118 Congress Street

Bike Racks

Parking Garage – Grit Separator

3 CITY OF PORTLAND BIKE RACK
L2.0 NOT TO SCALE

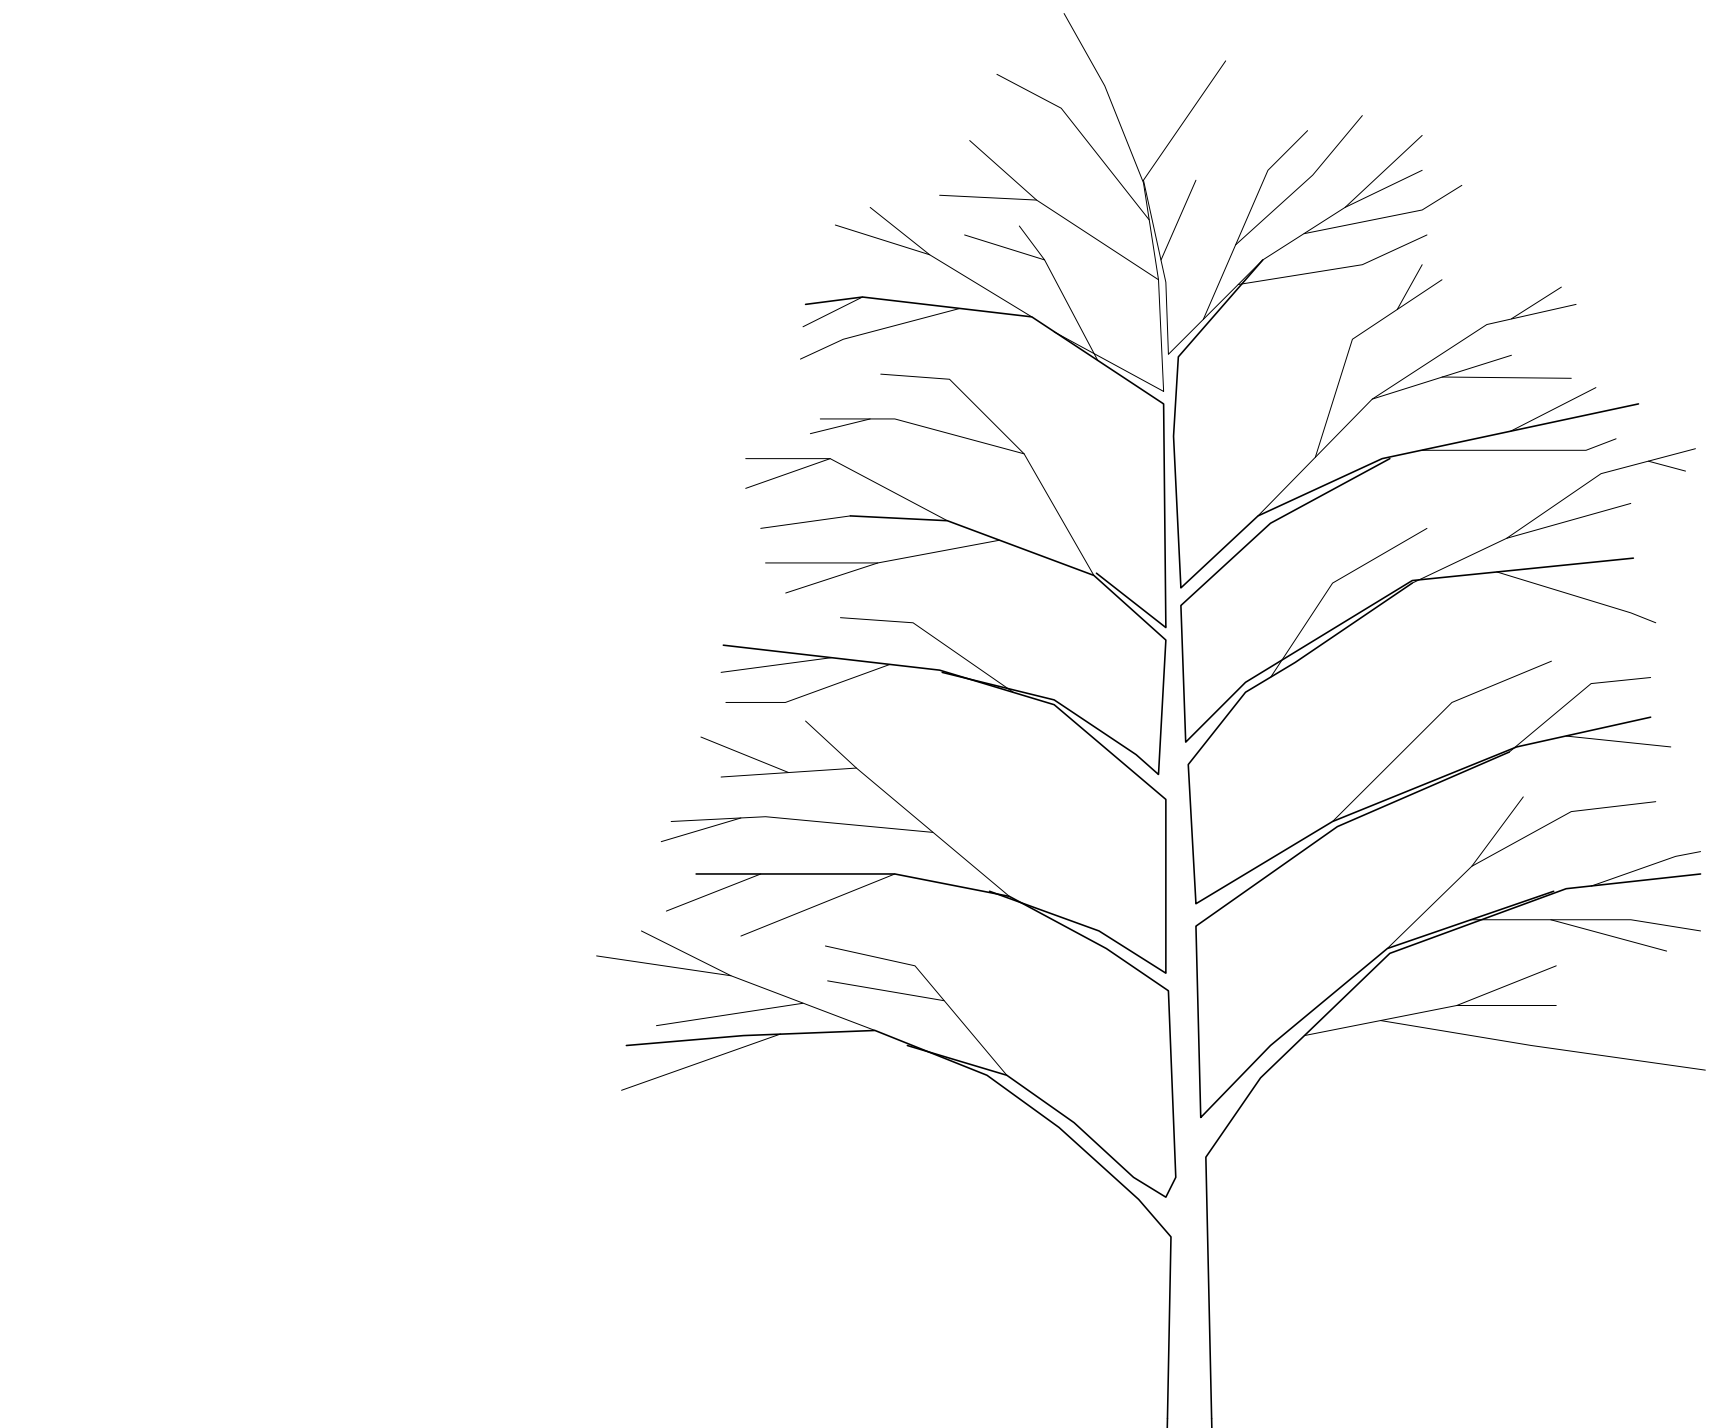
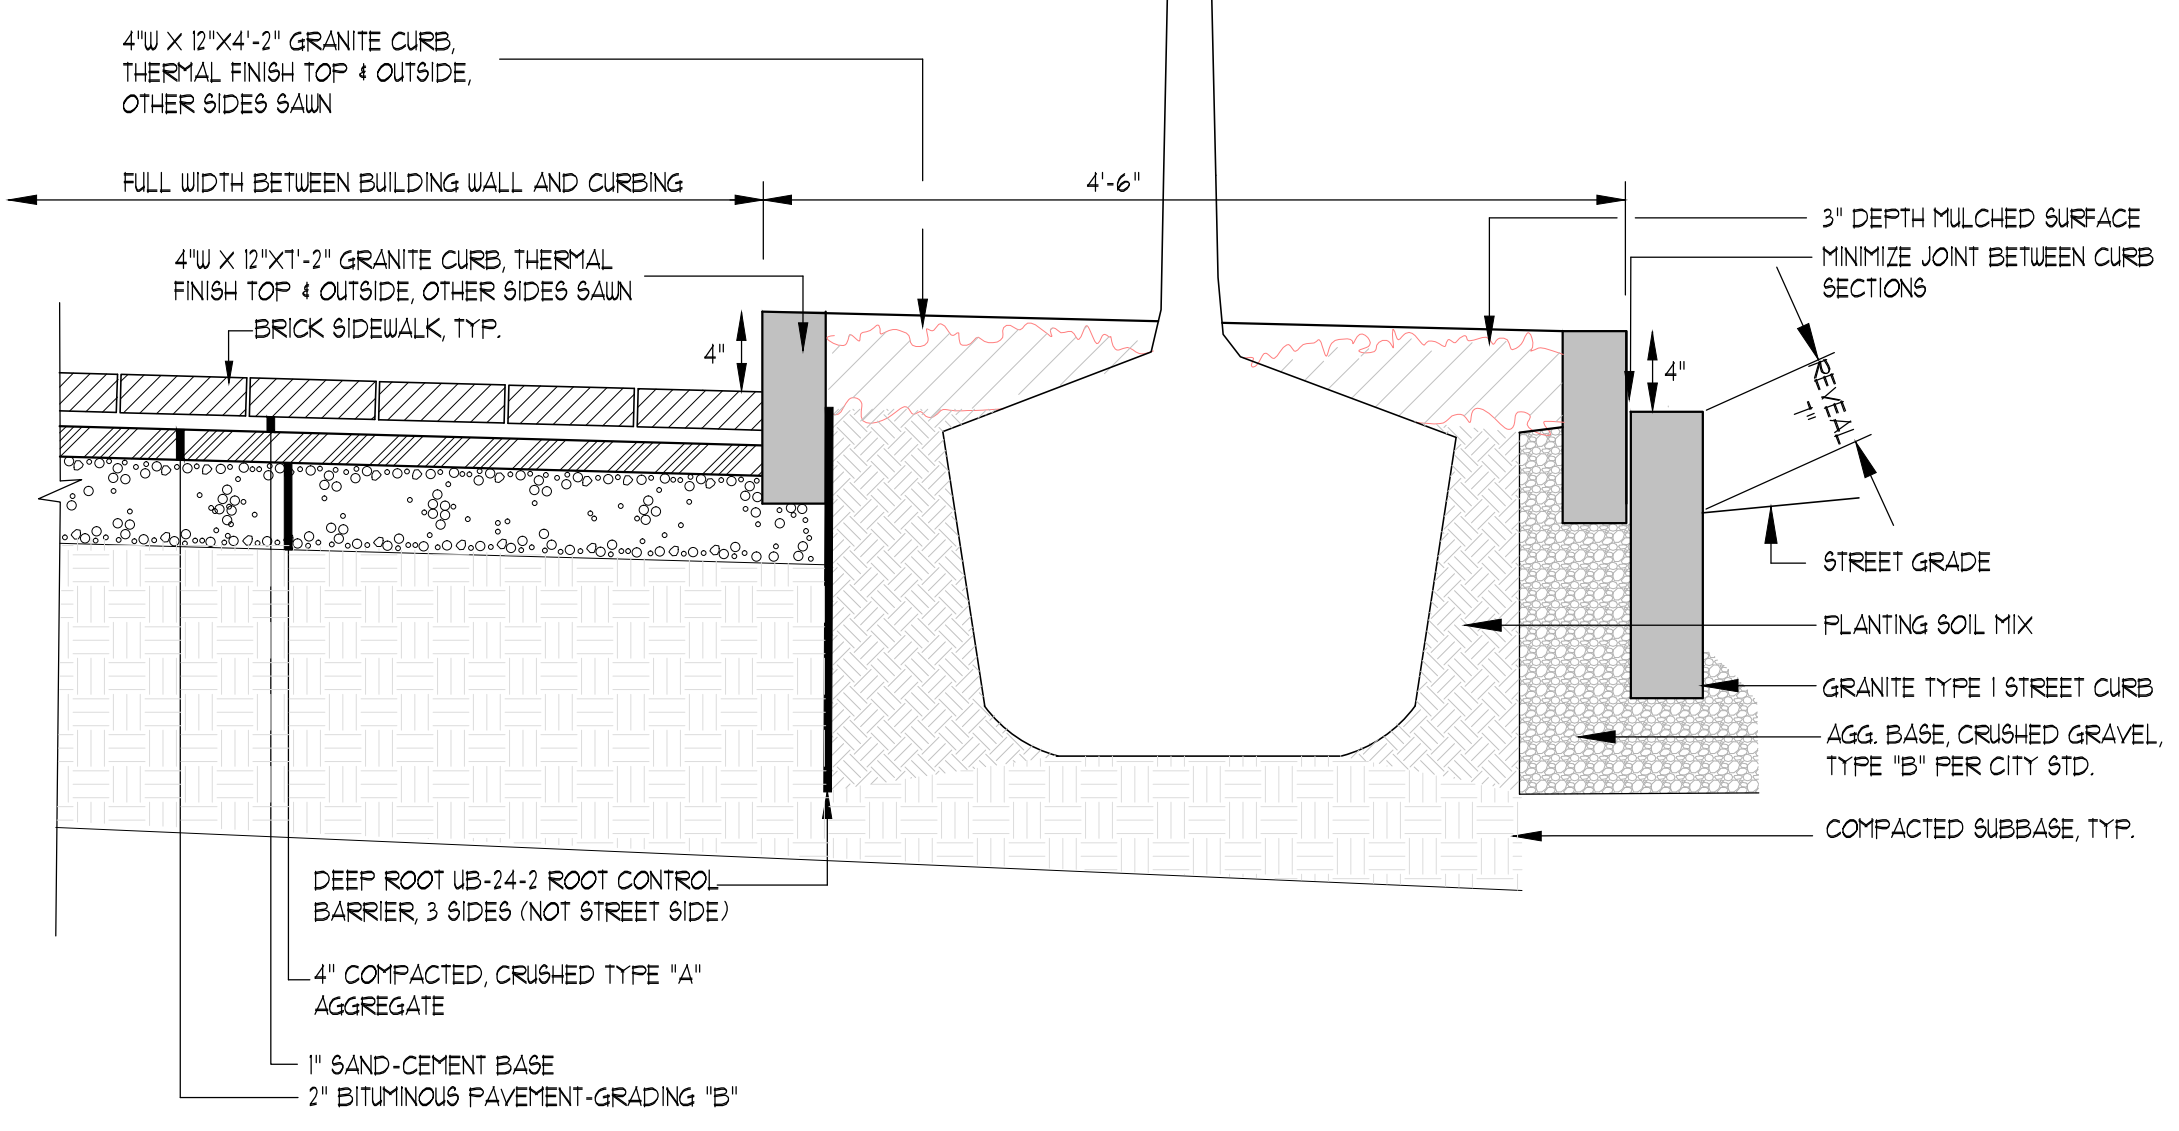
2. **Approved Plan: and Technical Manual Standards:** The custom rack was submitted in the original submission, but the final approved plans show two Dero bike racks meeting the City's standards located in the public sidewalk (shown above). Since the plan showed the required type of bike racks in the public right-of-way, this was not raised as an issue. An excerpt from the Transportation Section of the Technical Manual is as follows:

If it's in the public ROW we will not likely approve it (unless it was explicitly ALREADY part of the signed off/approved site plan). It would need to be a Bike Hitch or the Downtown Rack. We turned down a similar custom bike rack at the Press Hotel within the public ROW.

At the DPS meeting and the Development Review meeting, Tom Errico questioned the functionality of this bike rack. The longterm maintenance was also raised along with support for a unified municipal streetscape for such features, so it is clear the rack is for public use. Also, as designed it is hard to distinguish this as a bike rack versus signage for the building.

6. **Staff Recommendation:** The staff continues to recommend that the custom made bike rack be located on the private property and to retain the two Dero bike racks in the public right-of-way.

Drawing file: Landscape plan / Approved site Plan  118 Congress 13143-C1_2,REV7,041814.pdf

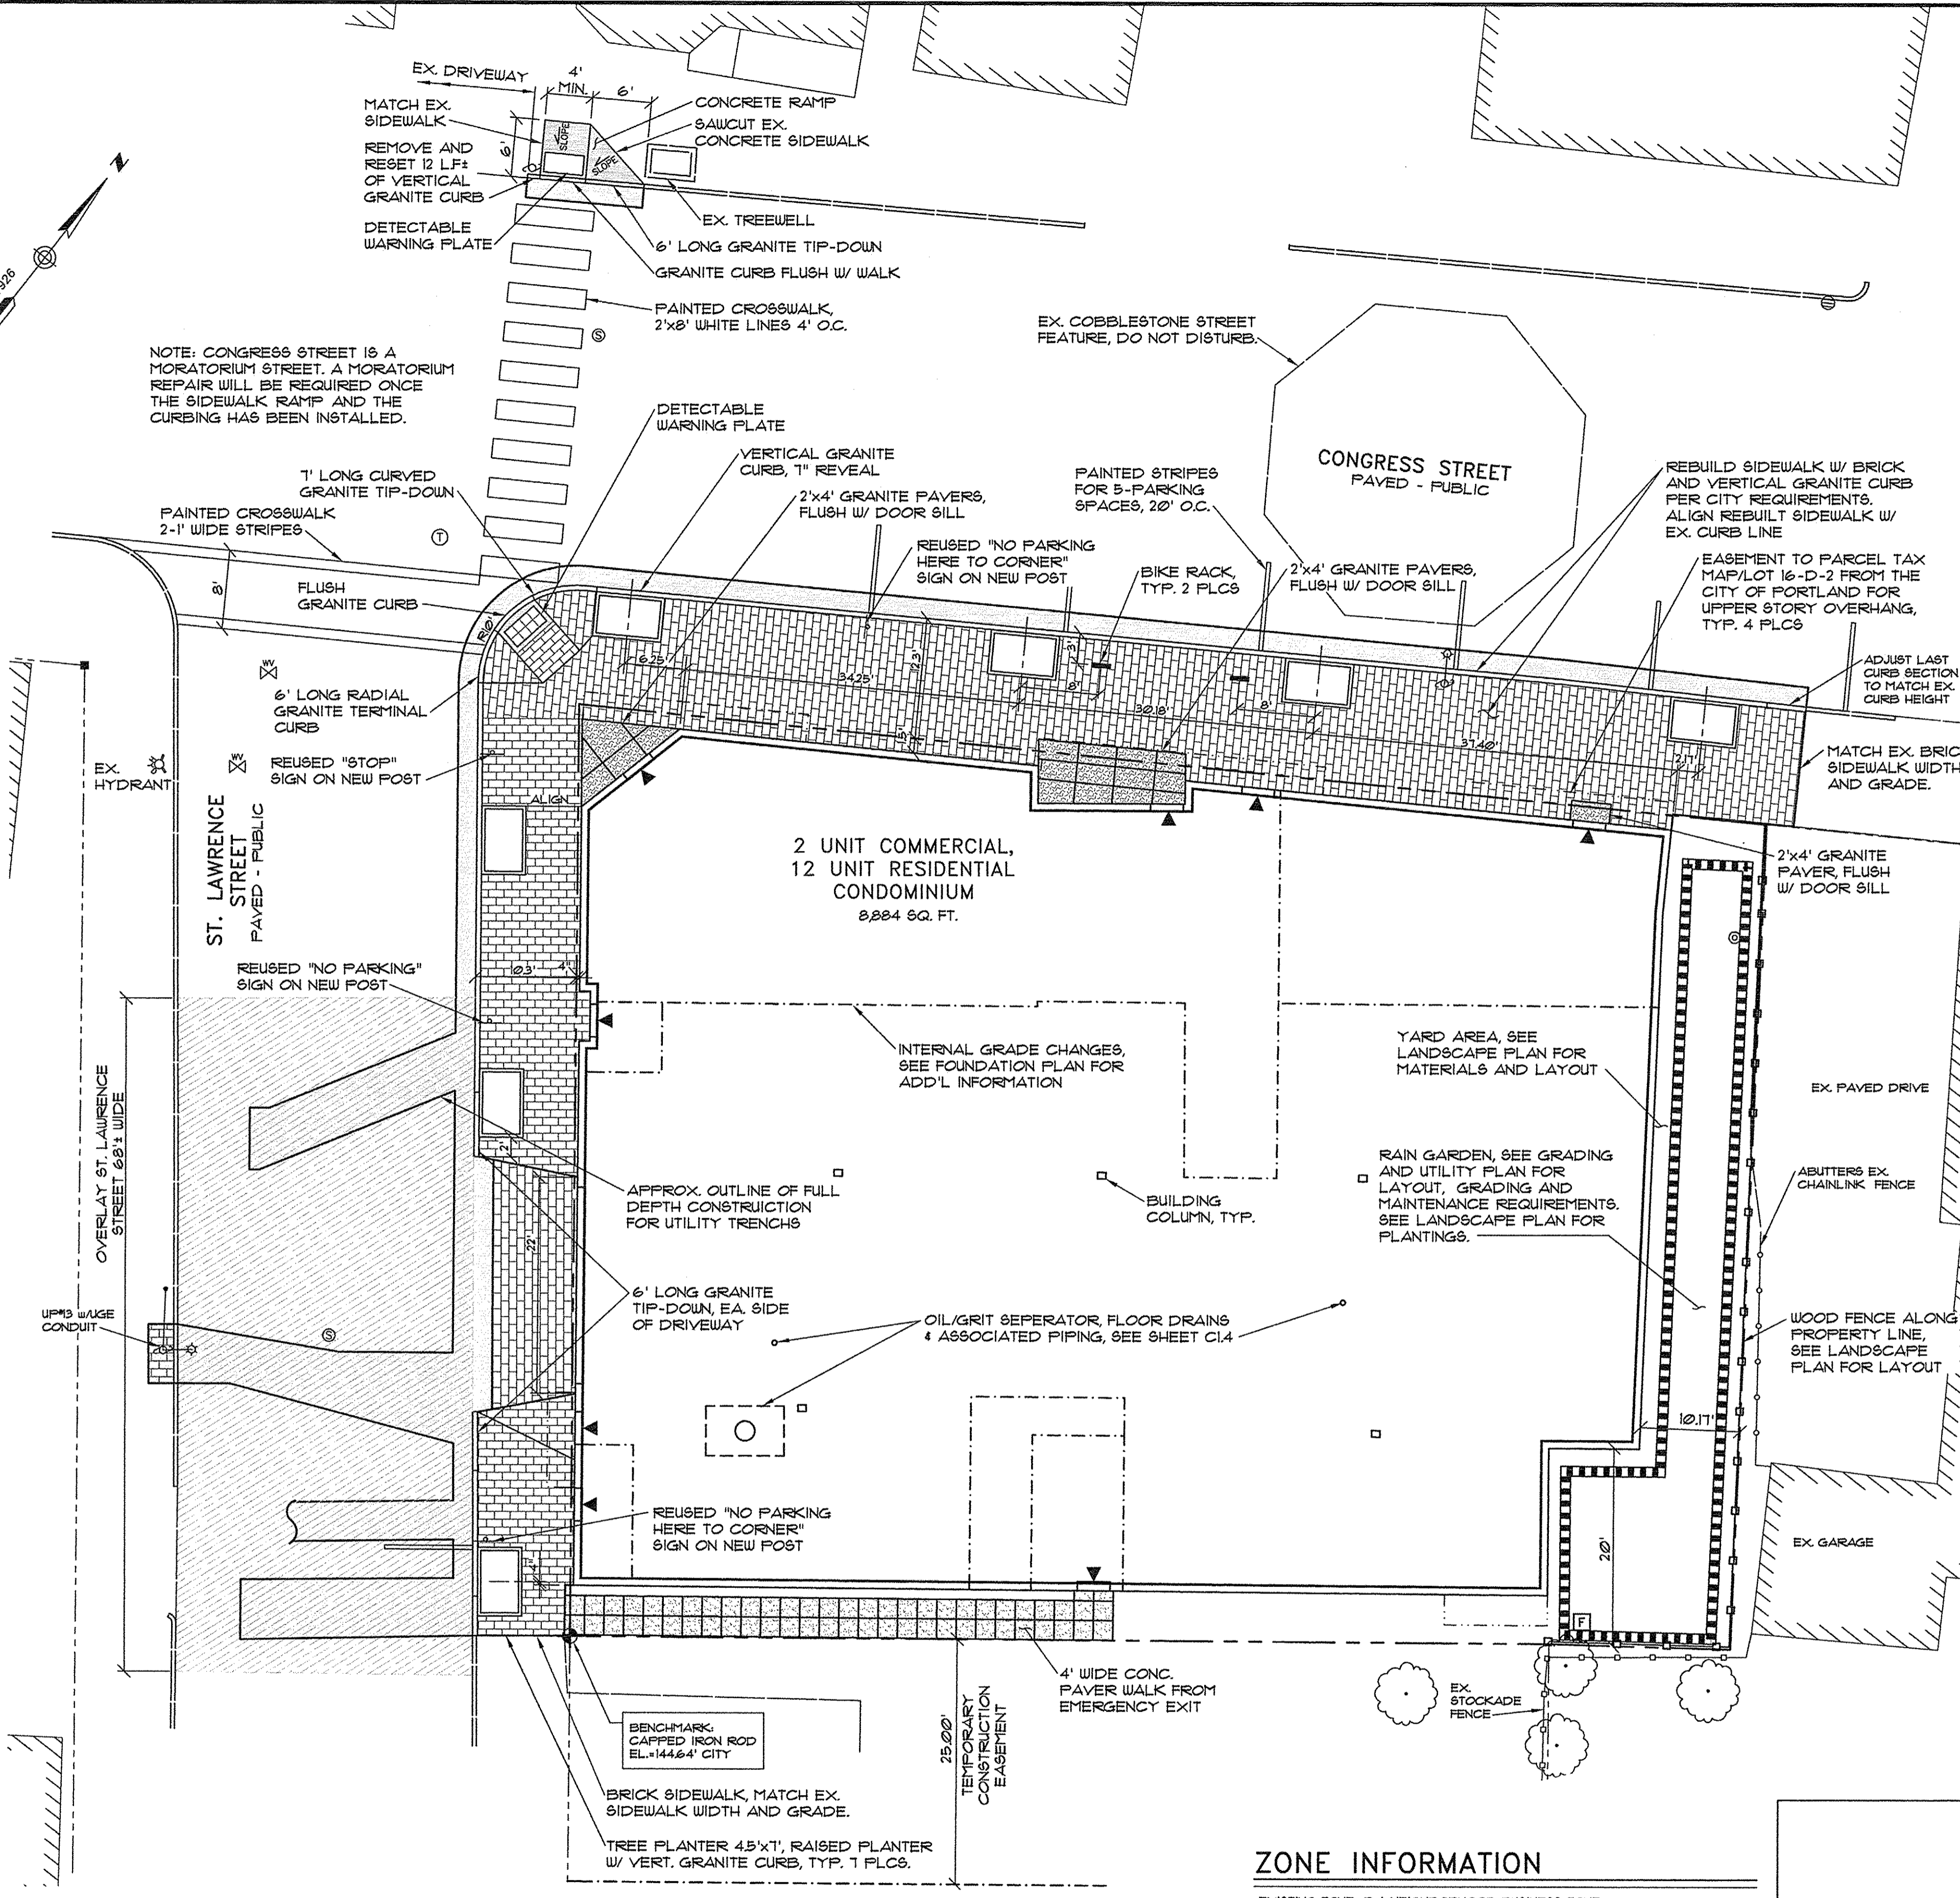
1. **Proposed Amendment to an Approved Plan:** On Wednesday, March, 18th, David Lloyd, representing Chip Newell, applicant, requested an amendment to the approved site plan to install a custom made bike rack in the public right-of-way parallel to the curb line. As part of the submission, Chip Newell has offered to have the condominium maintain and replace the bike rack (e-mail attached).
